MOSMAN MUNICIPAL COUNCIL

22 February 2008

Re: Proposed upgrade and Expansion of the d'Albora Marina, The Spit, Mosman

client	Ardent Leisure Pty Ltd	address	The Spit, Mosman	job no	DMS	drawing no
				drawn	CC	DA02
project	d'Albora Marina Refurbishment	title	Floor Plan L1	checked	mmk	issue
				scale	1:200	O
				@	A1

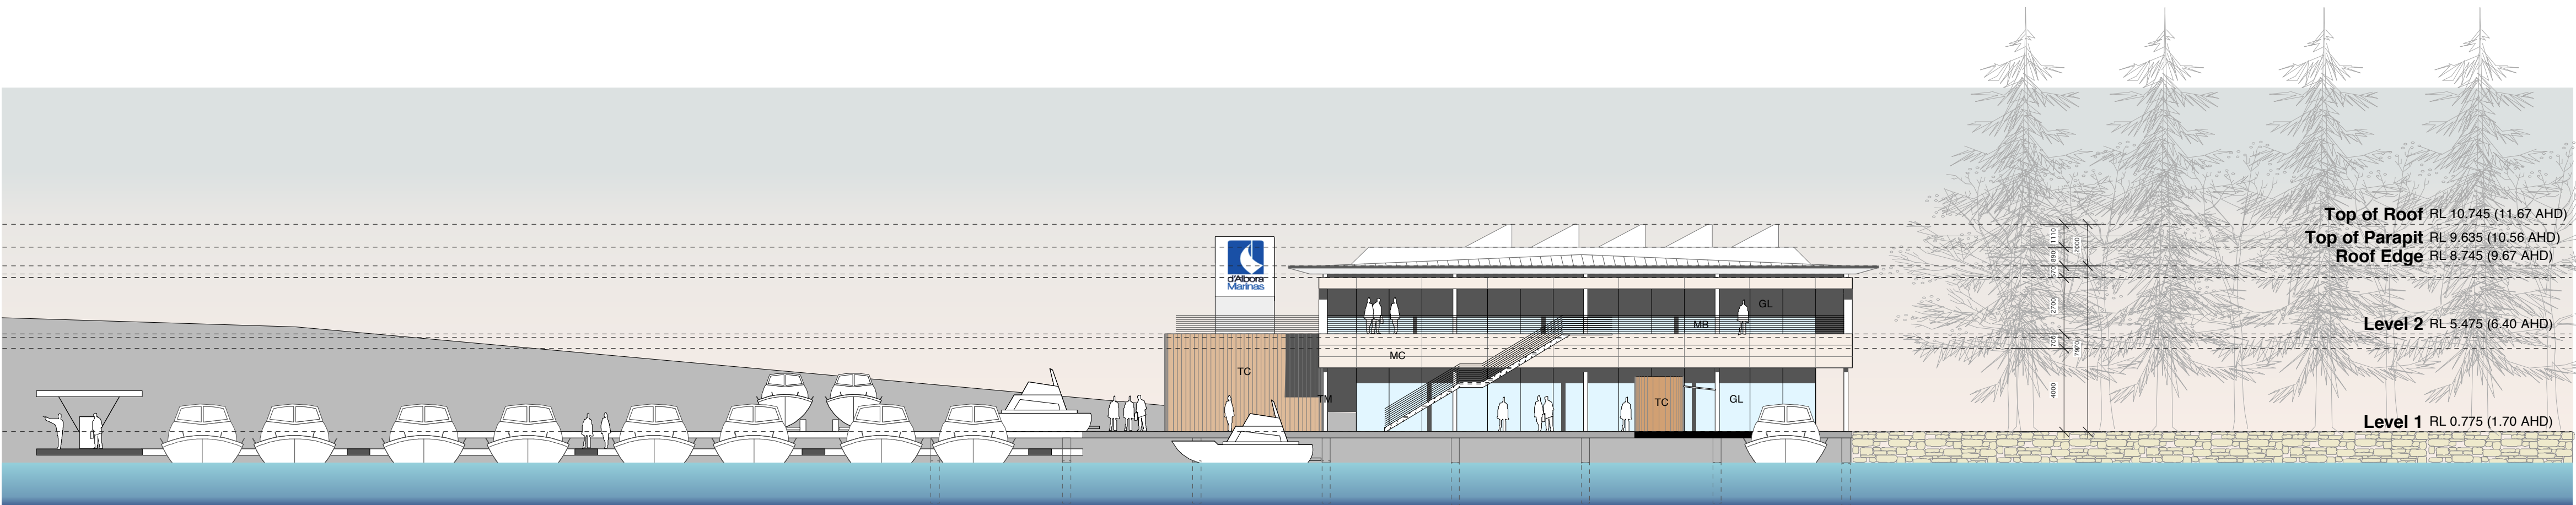
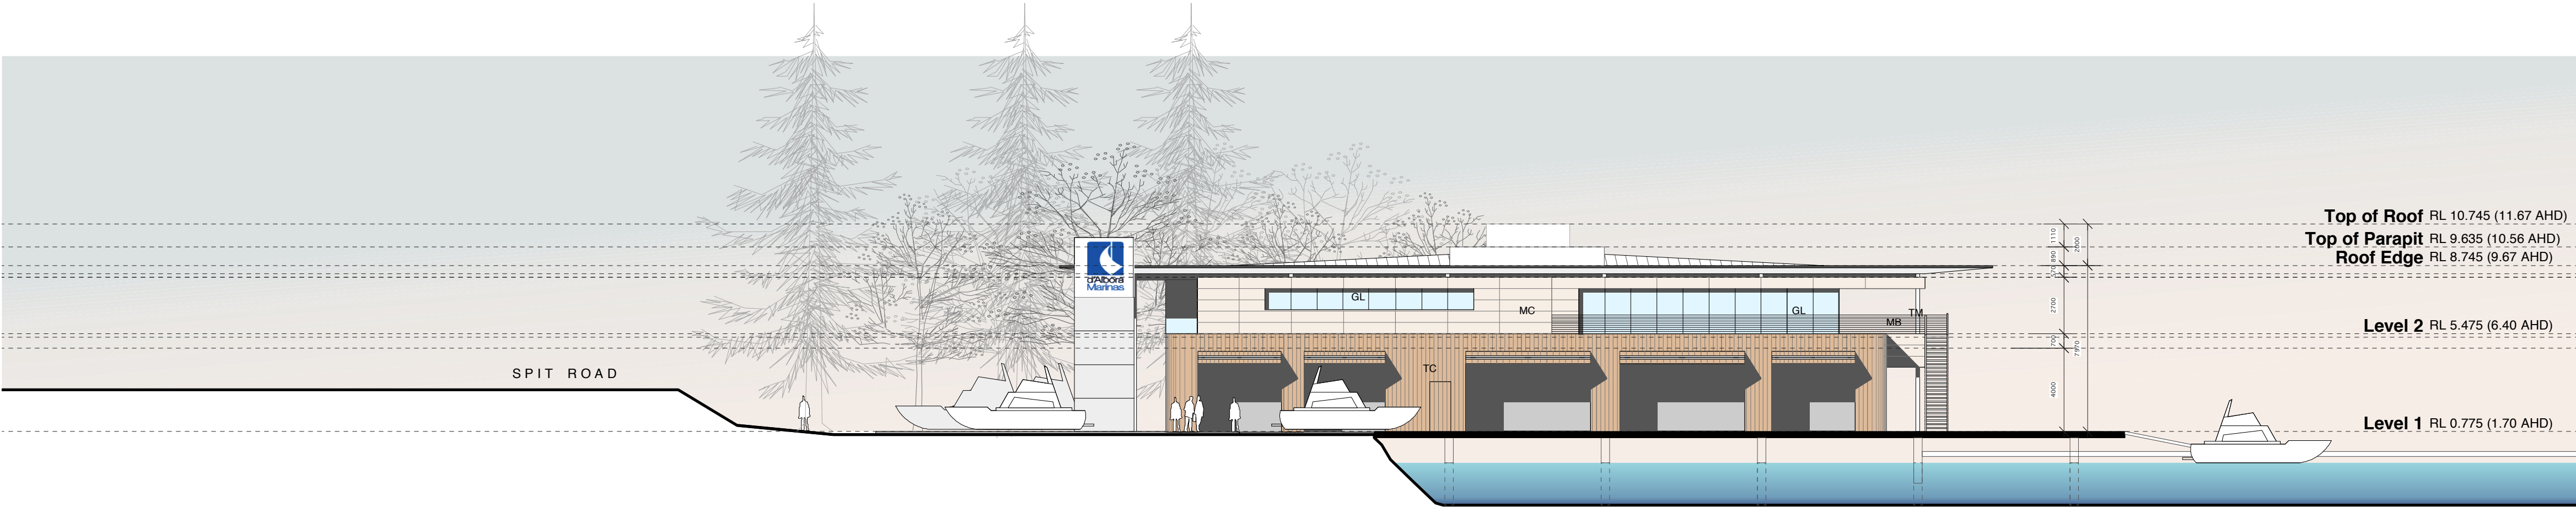
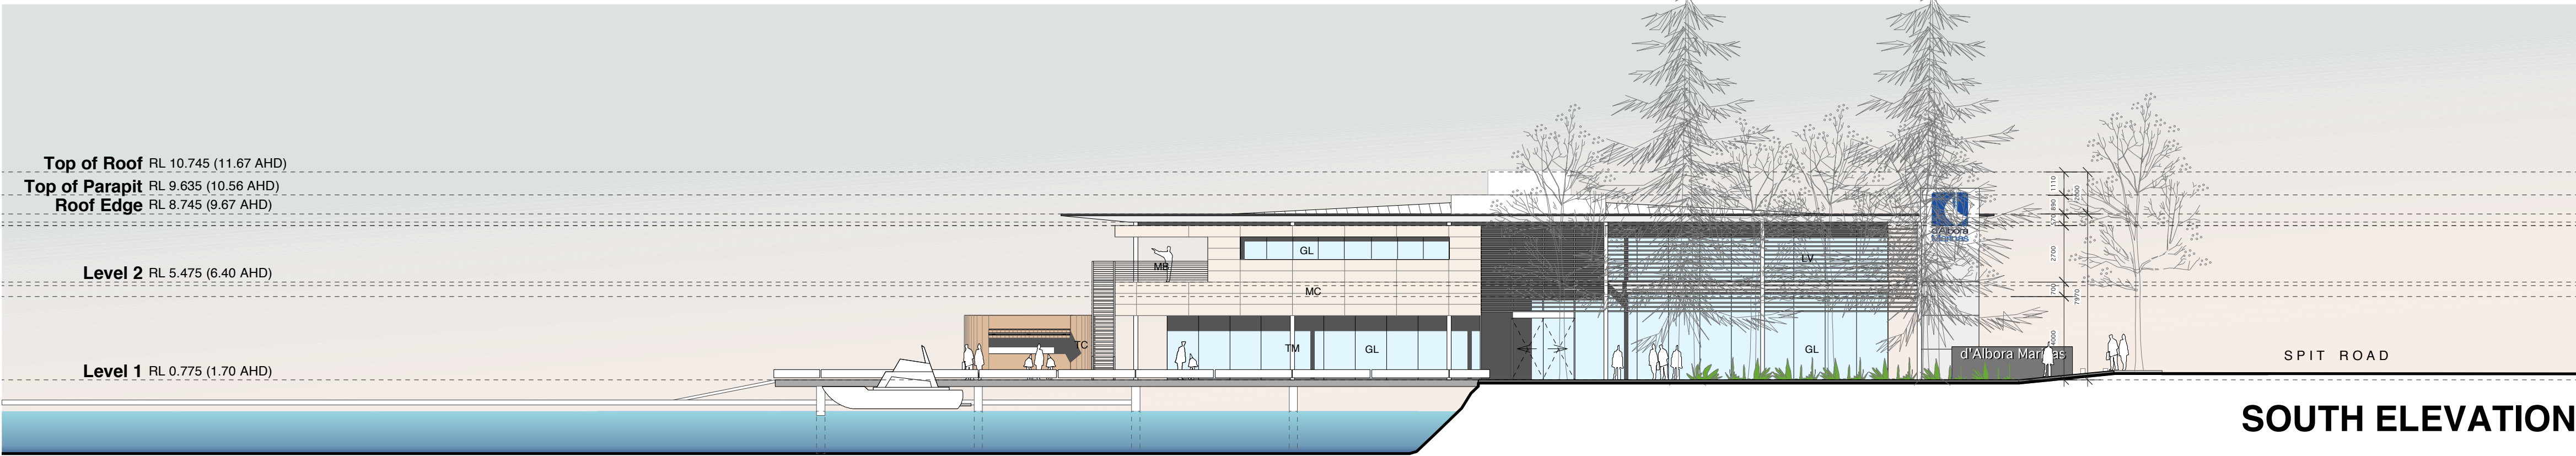
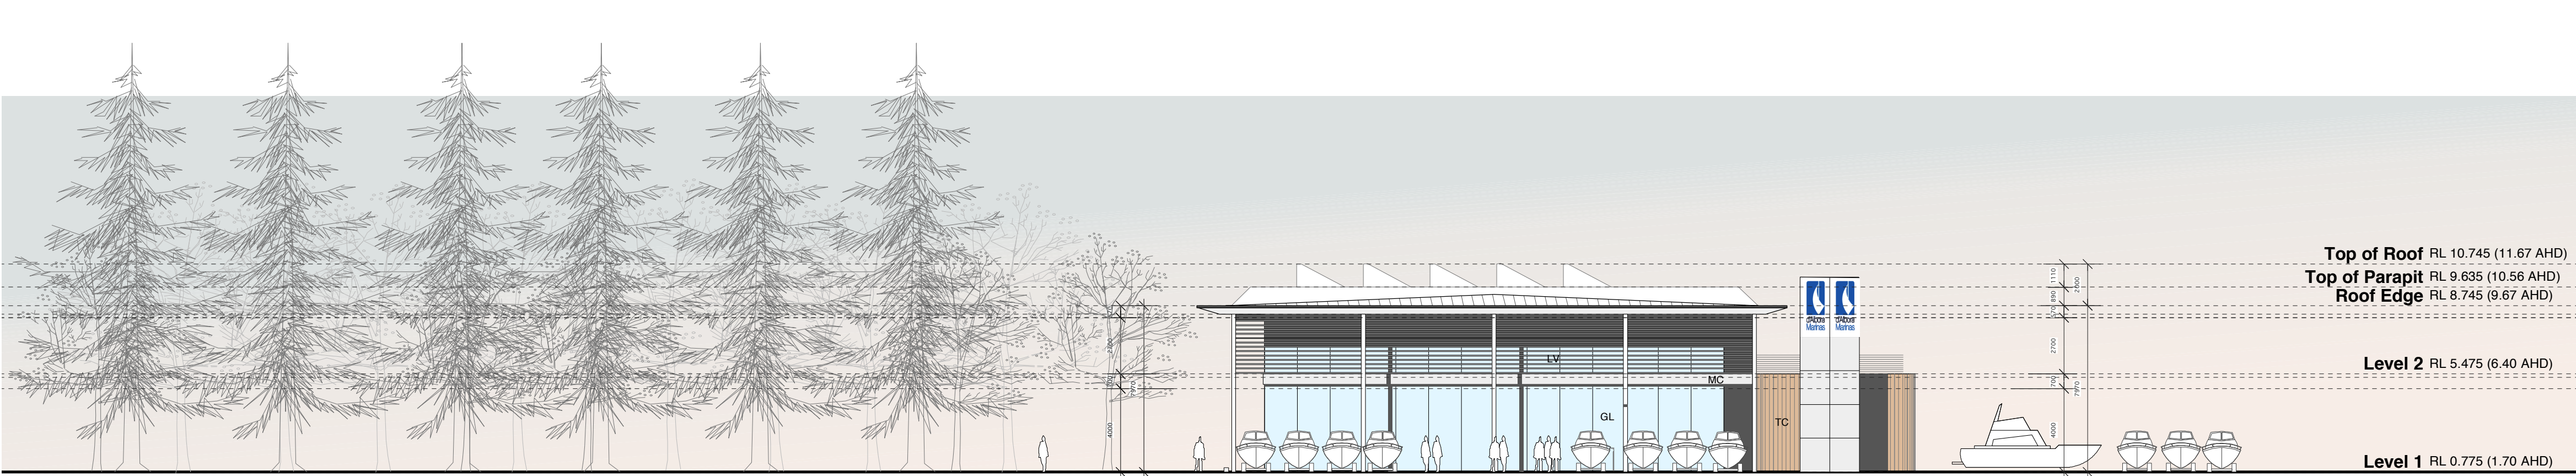
Whether the proposal maintains and improves public access to and along the foreshore is an issue. Drawing No. DA02 Issue C does not identify unobstructed public access along the foreshore.
